KIRKLEES METROPOLITAN COUNCIL INVESTMENT & REGENERATION SERVICE

Reference No:	2026/70/90683/W
Site Address:	14, Edgerton Road, Edgerton, Huddersfield, HD1 5RB
Description:	Variation of condition 2. (plans) on previous permission no. 2025/92383 for erection of rear and side dormers with rooflights at front and flat roof centrally (within a Conservation Area)
Recommending Officer:	Joshua Merriman

Officer Report – 2026/90683

Project Title
proposed elevations

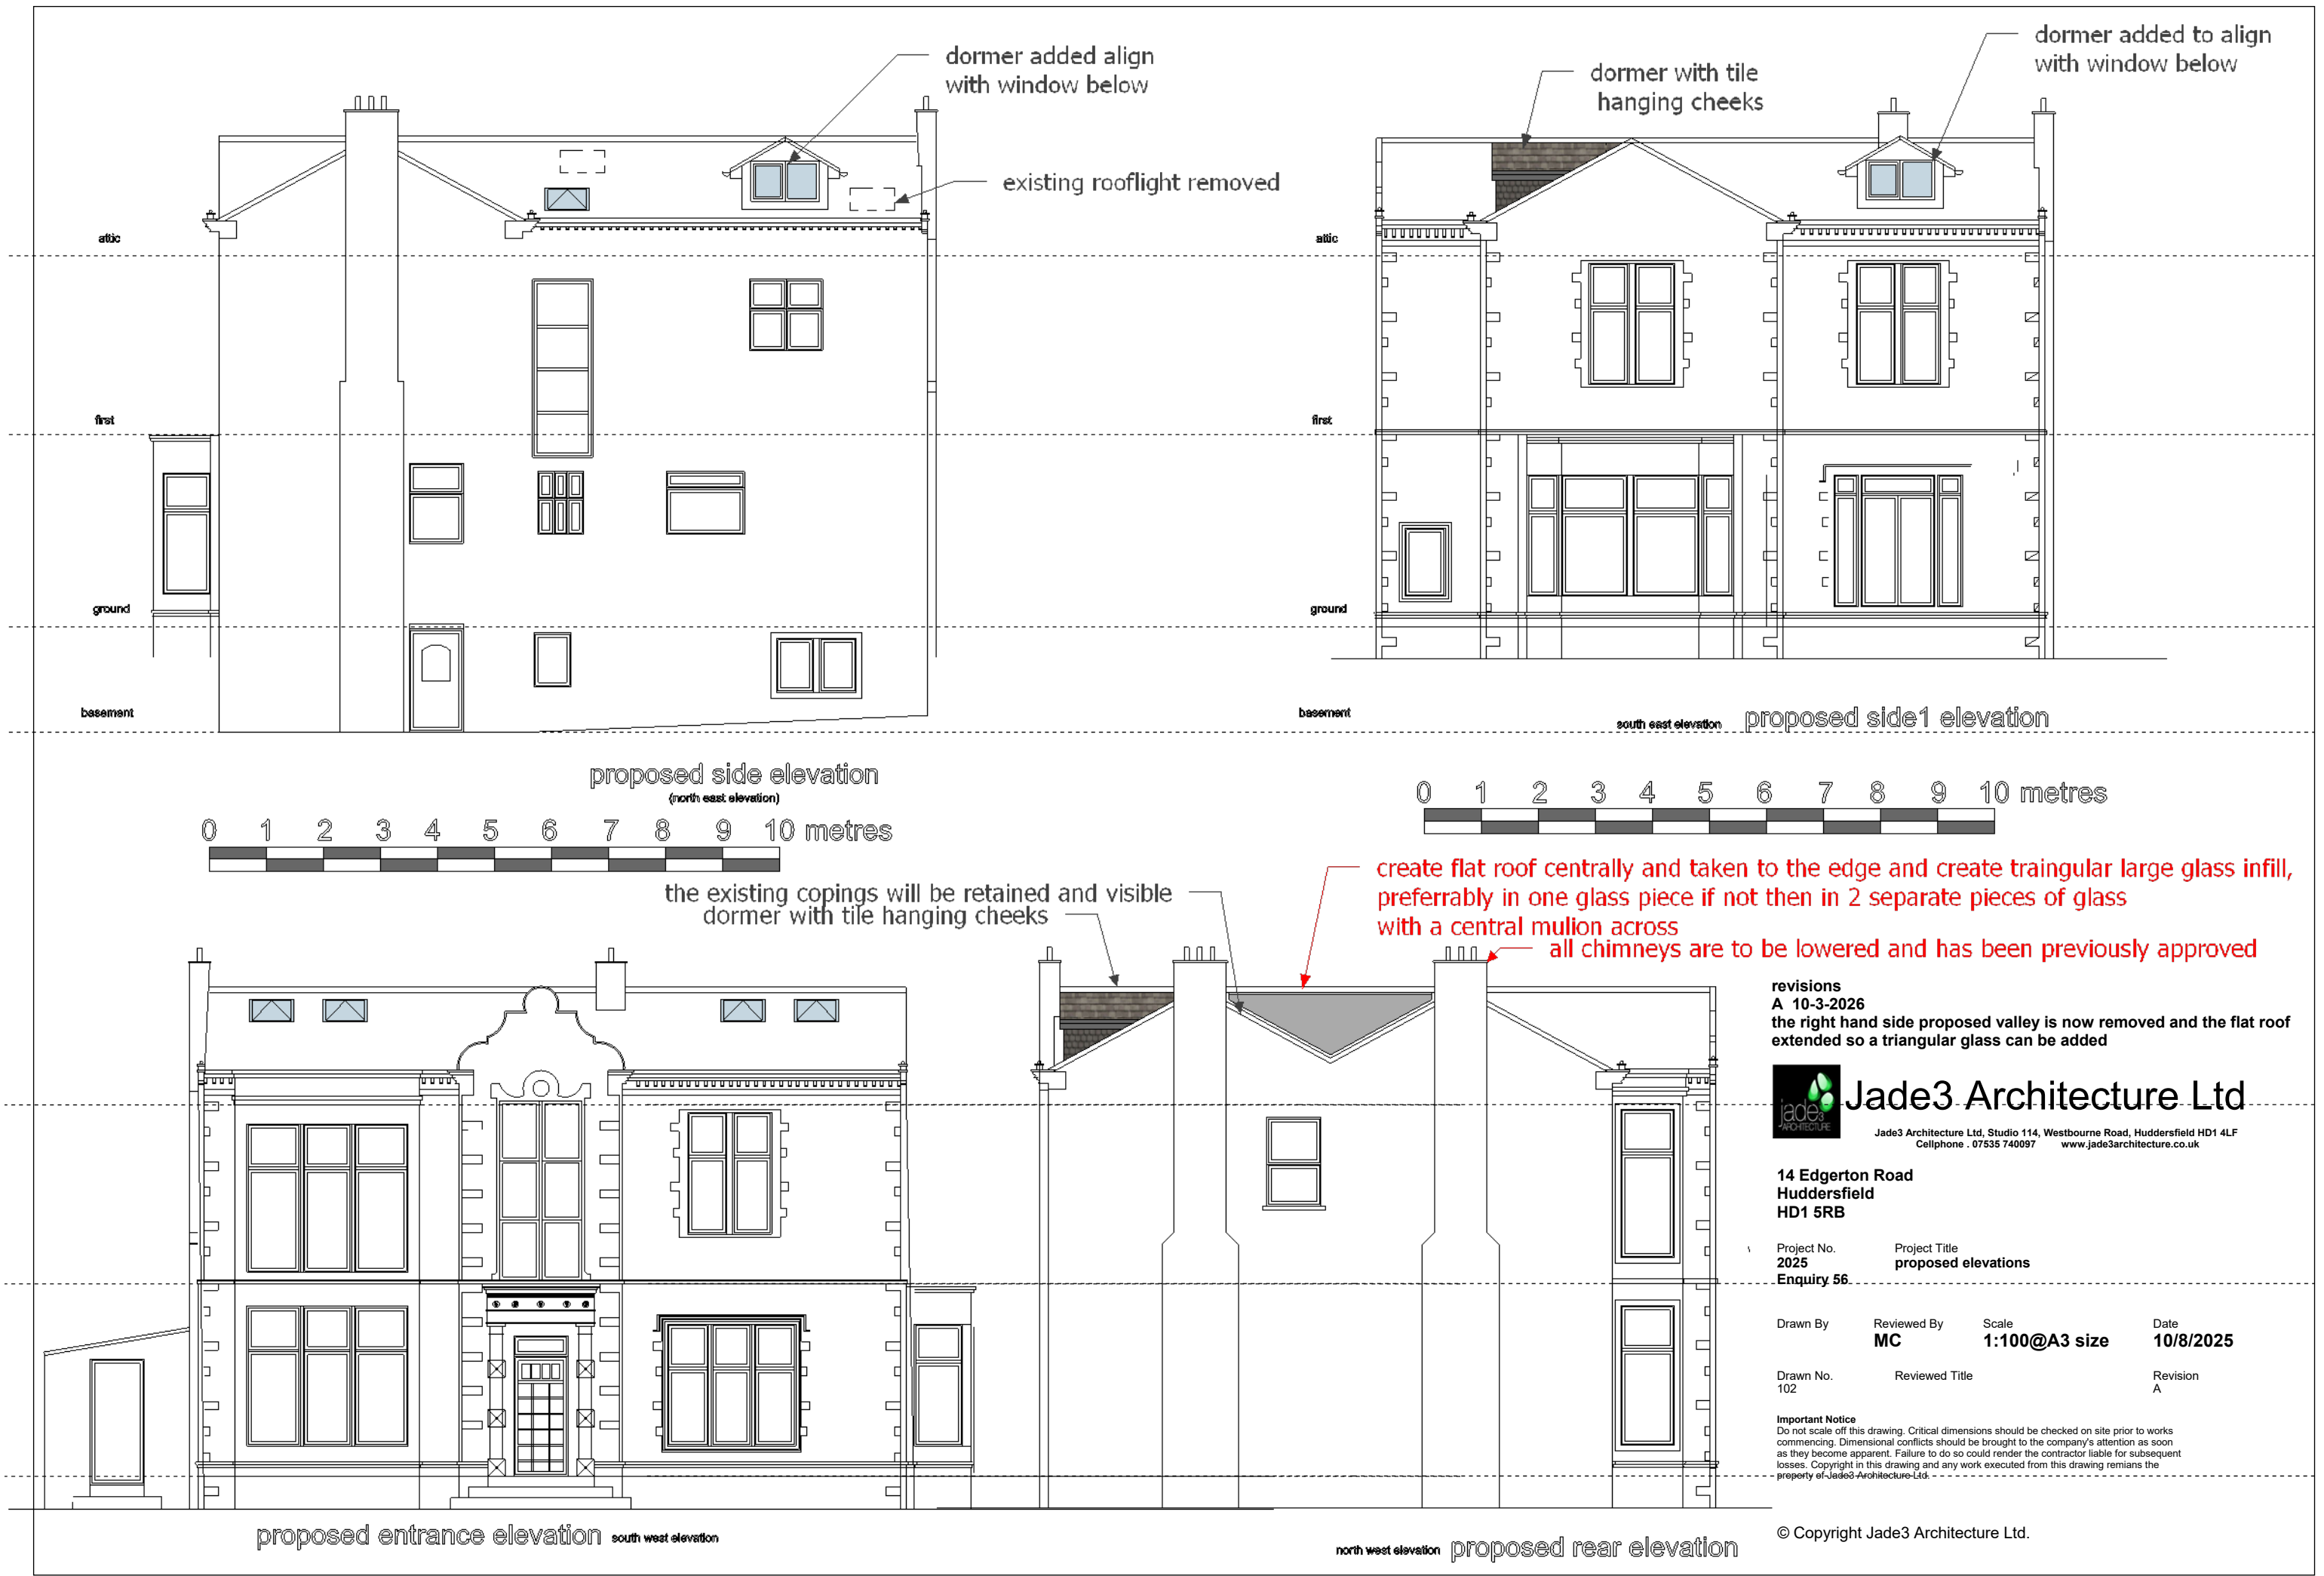
Officers have requested the reinstatement of the originally approved flat roof in scale, the removal of the proposed glass triangular roof item, and retaining the height of the existing chimneys by rebuilding them rather than decreasing their height.

KC Conservation & Design (Informal) – The rebuilding of the existing chimneys would be preferred as they are a primary to the character of the property, moreover, the use of a visible central flat roof and glass roof item are considered unacceptable due to the visual harm and harm to the character of the dwelling.

As the chimneys will be conditioned to be rebuilt as existing, and there are existing roof lights on the dwelling, it is considered that the proposed amendments will not be significantly out of character for the building, and are thus acceptable regarding visual amenity.
